Re: Submission/ Observations

An Bord Pleanála Ref: 313378

**Louth County Council Reference: 211499 – Michael Callan - Rathescar Middle/ Gunstown/
Whiteriver, Dunleer, Co. Louth.**

## DETAIL 2 - PASSING BAY DETAIL (4 Locations)

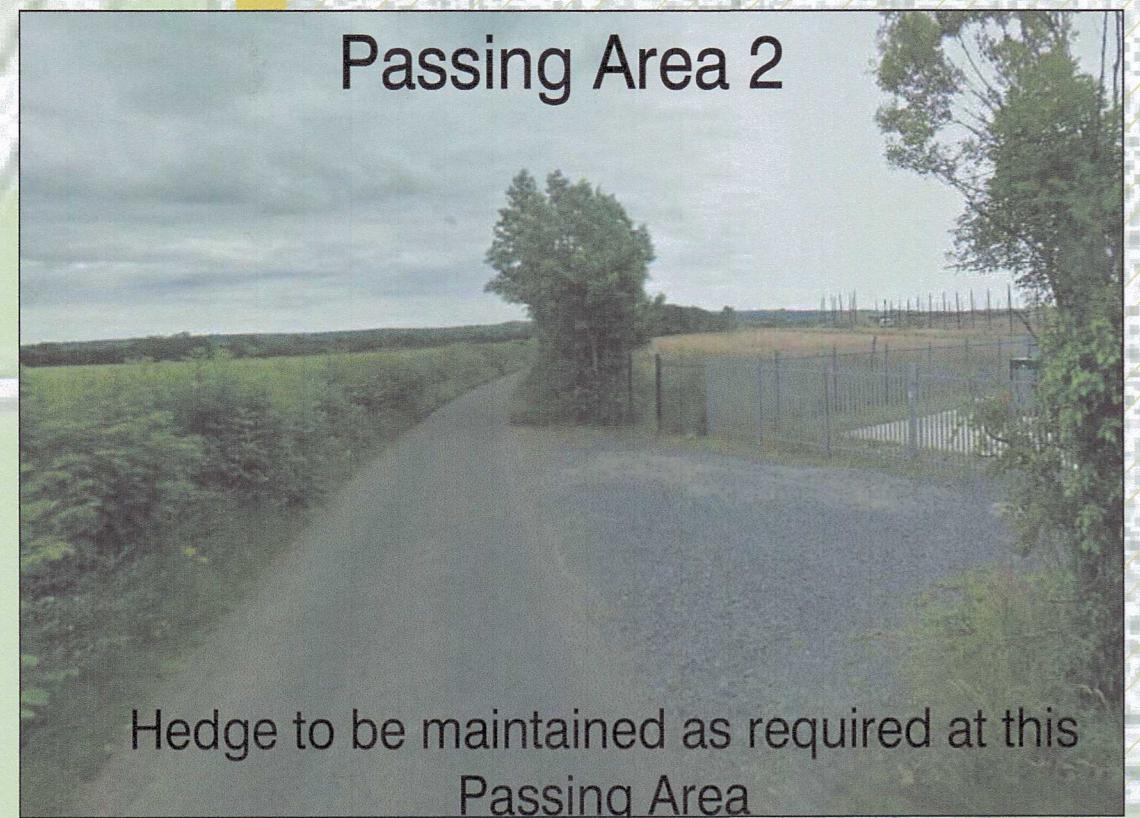
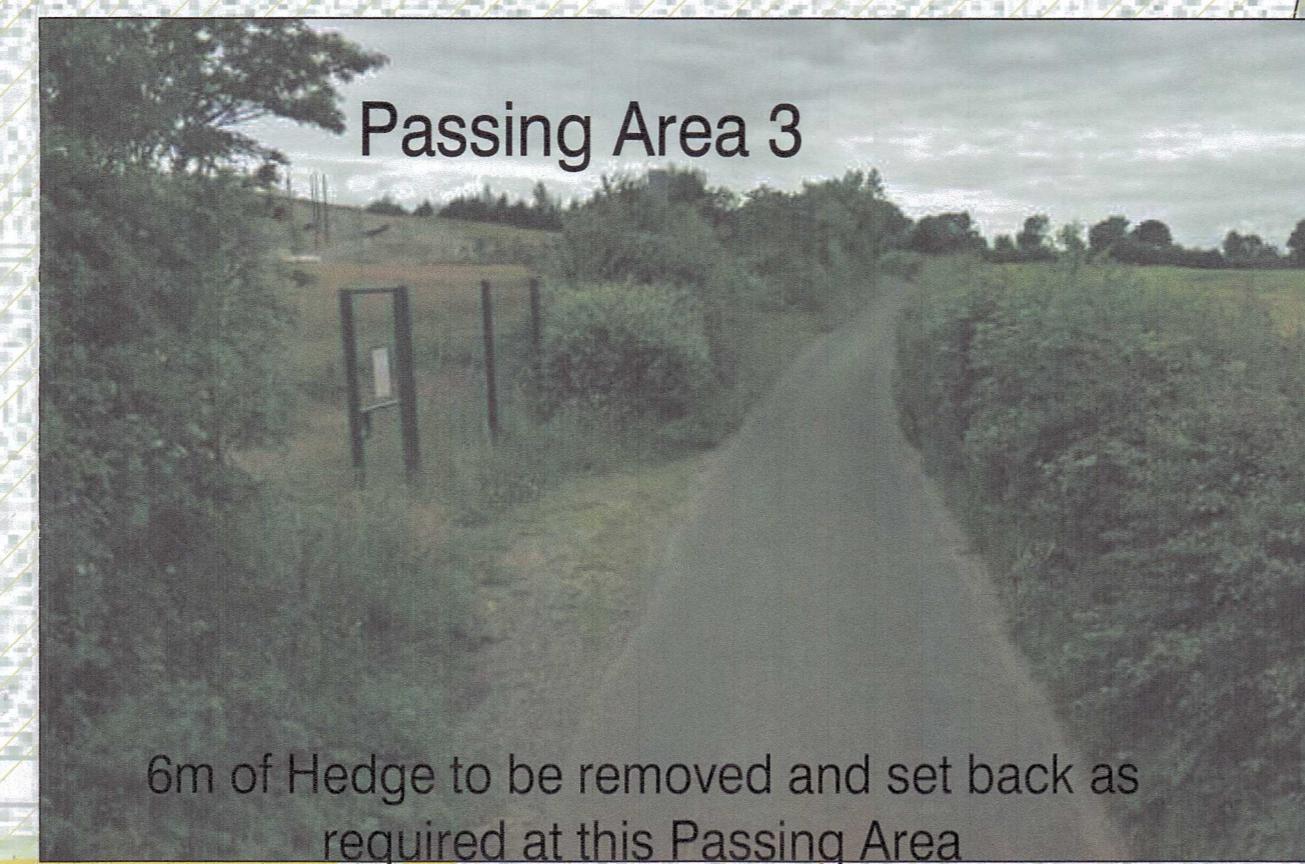
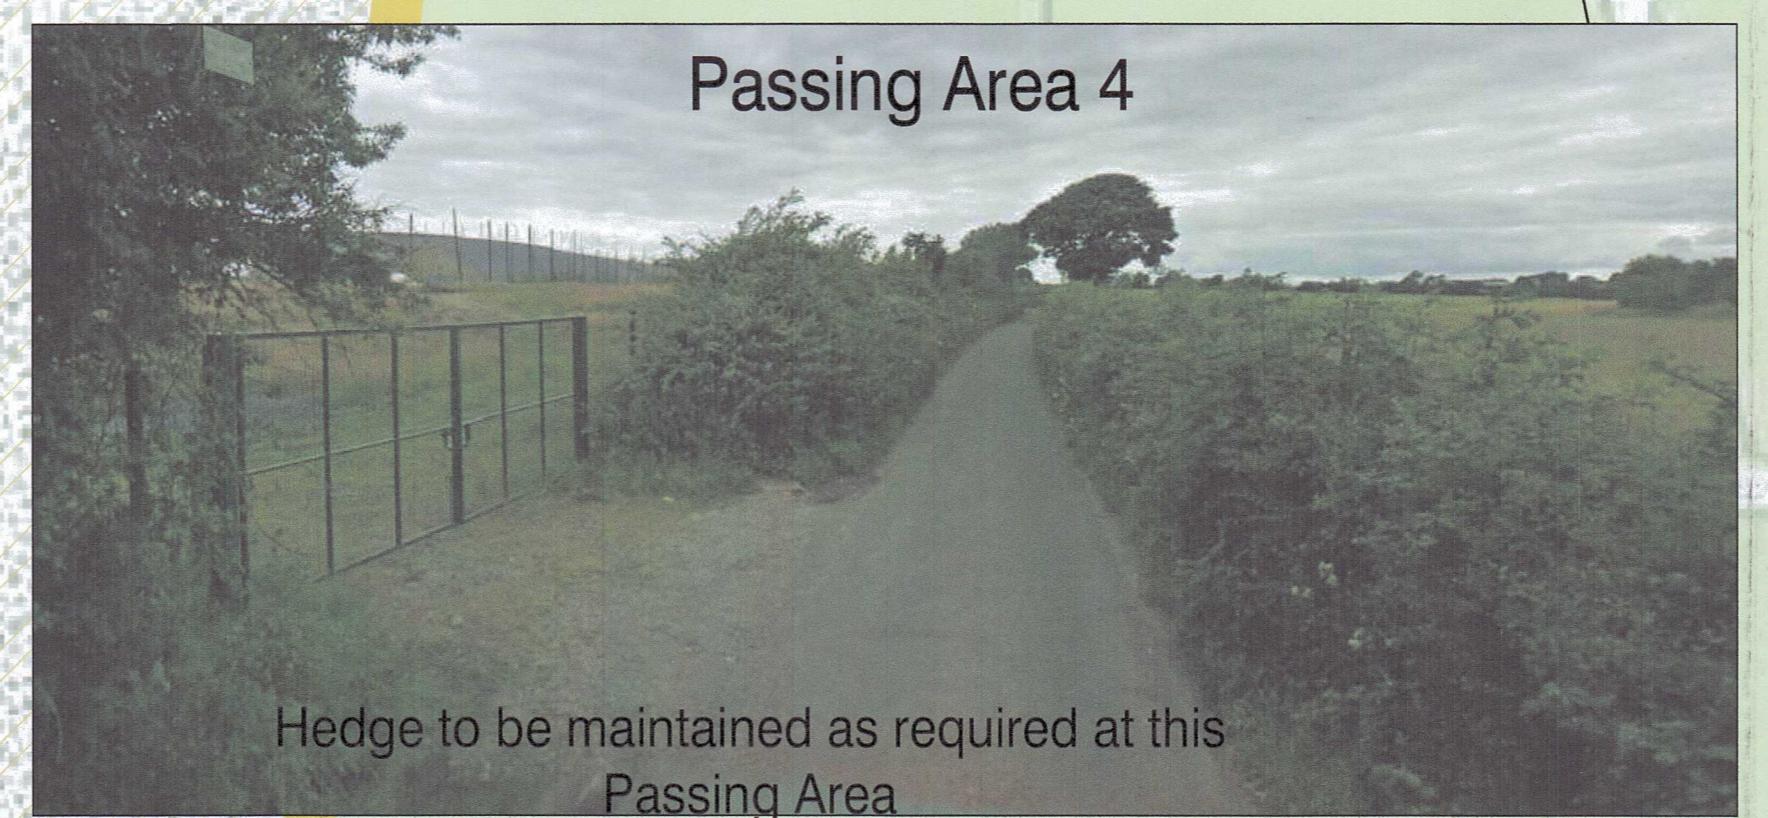
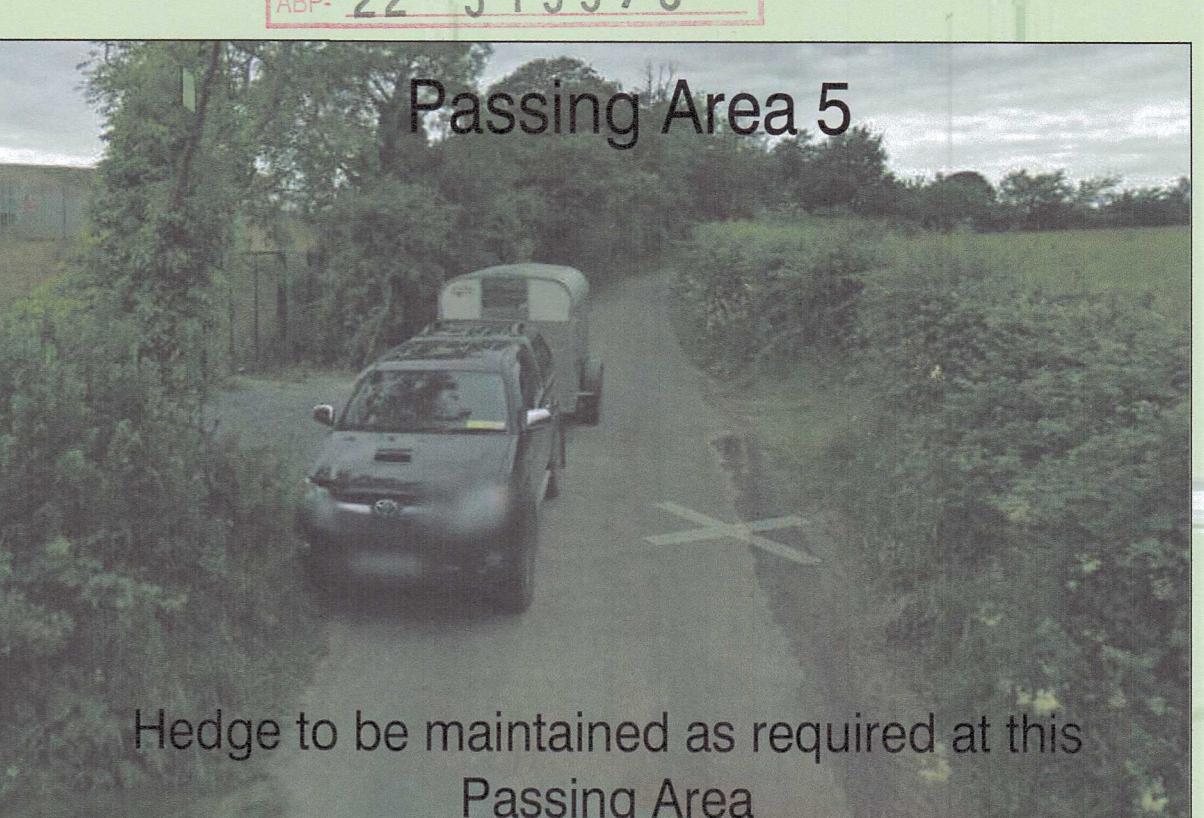
- The proposed trimming back/ removal of hedges for the four suggested lay-bys are not on the developer's land and would only affect a small portion of the road and therefore would not facilitate the whole road that would be affected by the development. There is no supporting documentation with the planning application to show that the developer has gained approval from the other land owner(s) to carry out any works to lands not under his control. Should the lay-bys be approved, the road will still be too narrow for two standard vehicles to pass never mind a HGV.

- The road concerned already has extremely poor visibility. The suggested widening of lay-bys will not improve this issue and would give additional concern for serious road accidents. The road as it stands is too narrow for two-way traffic. The suggested installation/ widening of lay-bys will not change this issue. In addition, if these lay-bys are approved it would give rise to antisocial behaviour in the area.

- The developer has suggested in the planning application that the lay-bys would be on the county council's land. There was no documentation to say that the county council has granted approval for this and it is concerning that this type of approval would be granted to a commercial developer.

AN TÓIR PLEÁNÁLA  
PROPOSED SITE ENTRANCE 17 APR 2022  
LTR DATED \_\_\_\_\_ FROM \_\_\_\_\_  
LDG: \_\_\_\_\_ ABP: 22 - 3 1 3 3 7 8

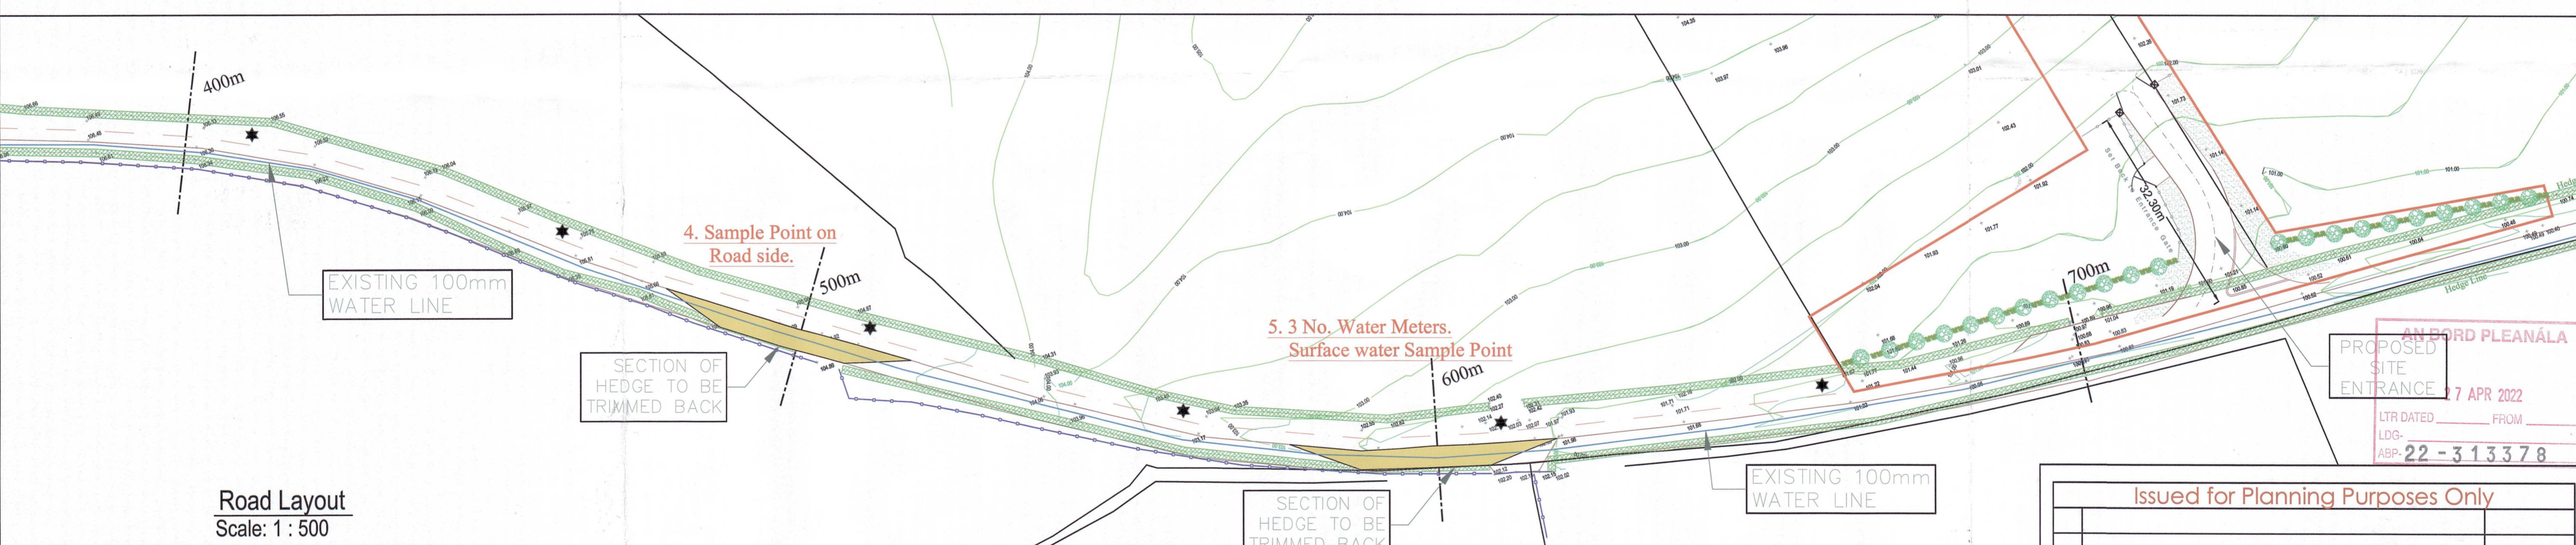
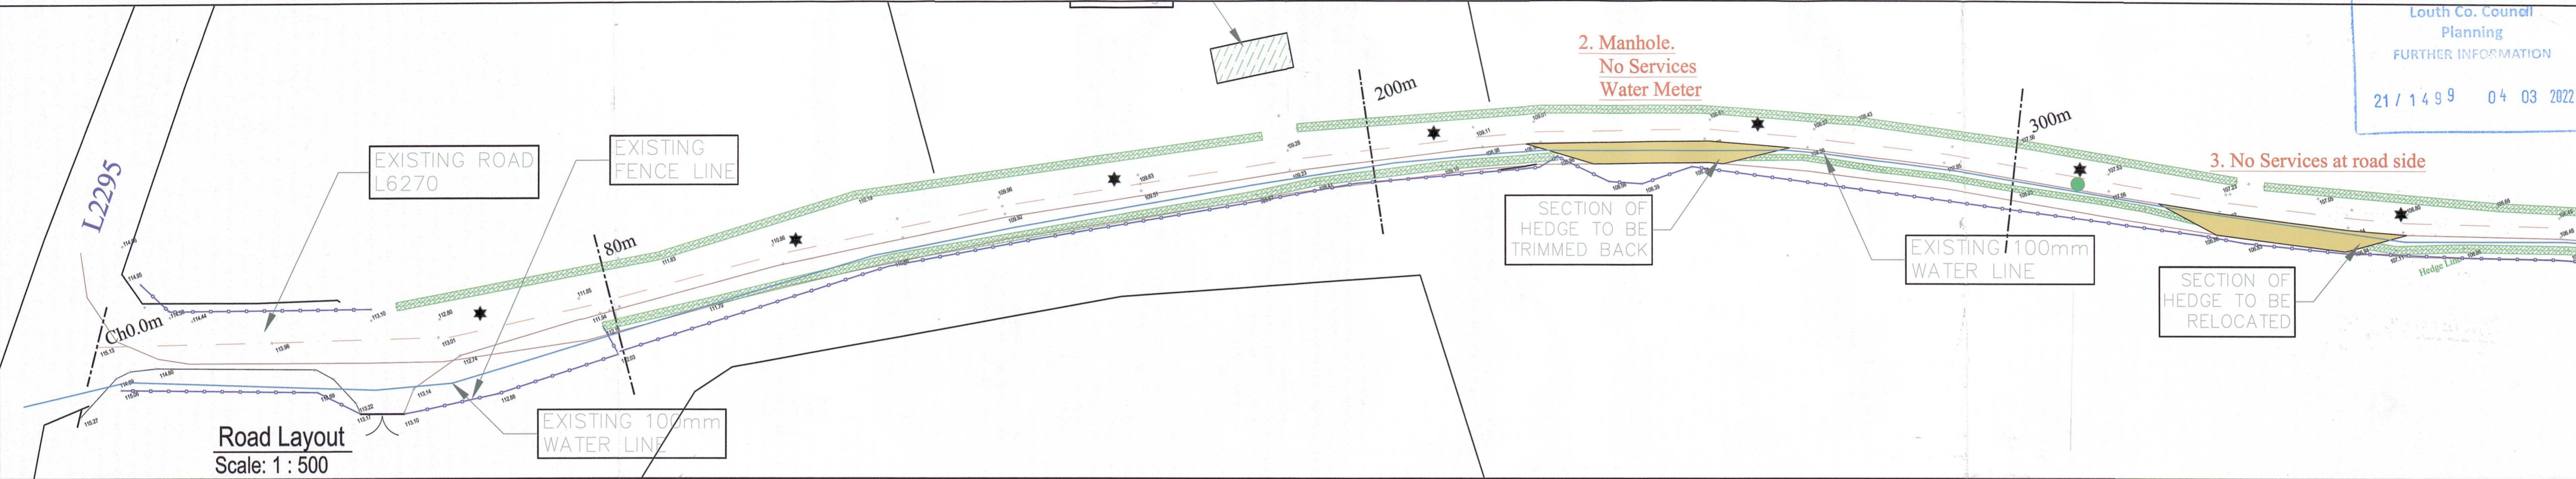
- The proposed entrance does not have the required sight visibility which again would cause extreme dangers to road users.
